Date: 09-Sep-2026
Our Ref: 2026/92299

**Application for a non-material amendment following a grant of planning permission,
Town and Country Planning Act 1990**

**Non material amendment to previous permission 2021/94622 for Reserved Matters
application pursuant to outline permission 2018/60/91787/E for demolition of
existing buildings and structures and erection of residential development
Greenside Mills, Saville Road, Skelmanthorpe, Huddersfield, HD8 9EE
Application Number: 2026/92299**

Indicative Section E-E,
1.0m Gravity Wall
1:50

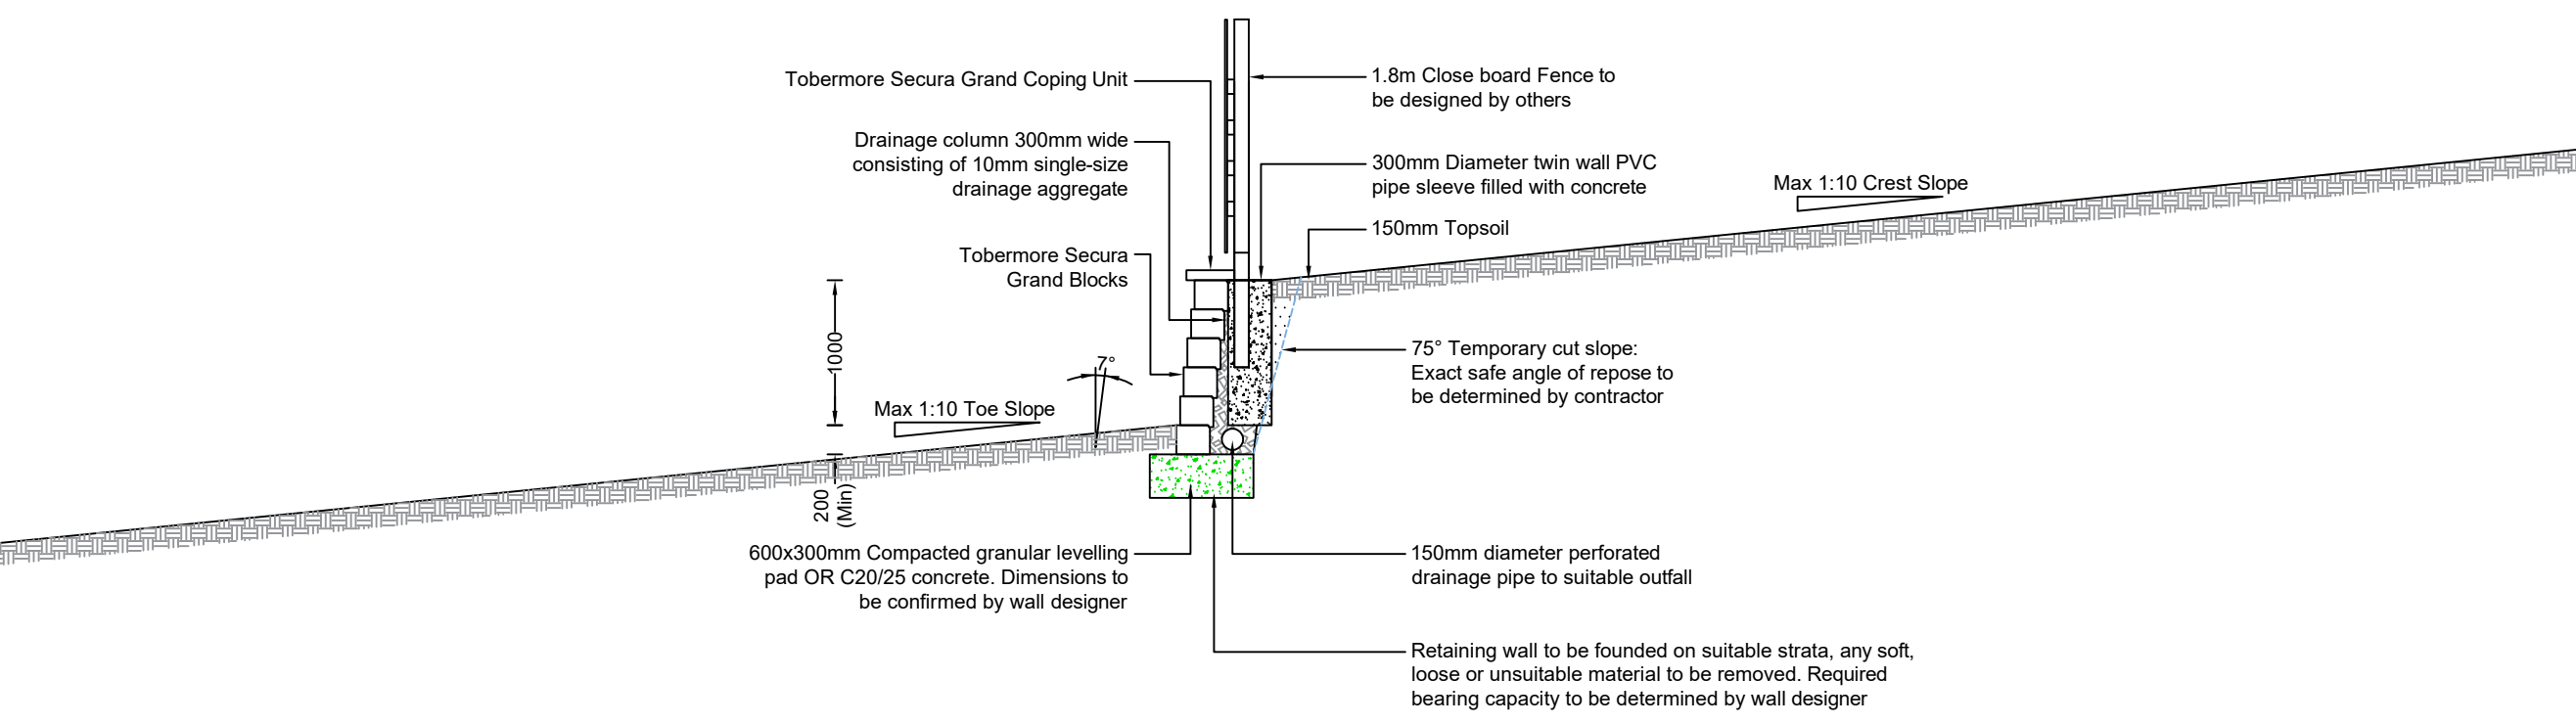
- To amend the construction of the identified retaining walls from walls faced in Cromwell weathered pitch face artificial stone to either a 'Tobermore' interlocking concrete construction, in colour 'Bracken' as shown on the Tobermore Secura Grand webpage (and confirmed via email correspondence from the applicant), or facing concrete walls in the Bracken modules.

I can confirm that the proposed alterations, as outlined above, are acceptable and may be considered as a non-material amendment to the approved drawings. This is subject to the

walls being constructed in Bracken colour. As such, condition 15 is hereby amended to read:

15. The hereby approved dwellings shall be externally faced in 'Cromwell Weathered Pitch Face' artificial stone. In accordance with plan drawing reference 2156.66 Rev A the retaining walls identified by a blue line shall be faced in 'Cromwell Weathered Pitch Face' artificial stone. All other retaining walls shown on plan drawing reference 2156.66 Rev A shall be faced in Tobermore concrete walling: colour 'Bracken' as shown on Tobermore Secura Grand webpage unless otherwise agreed in writing by the Local Planning Authority.
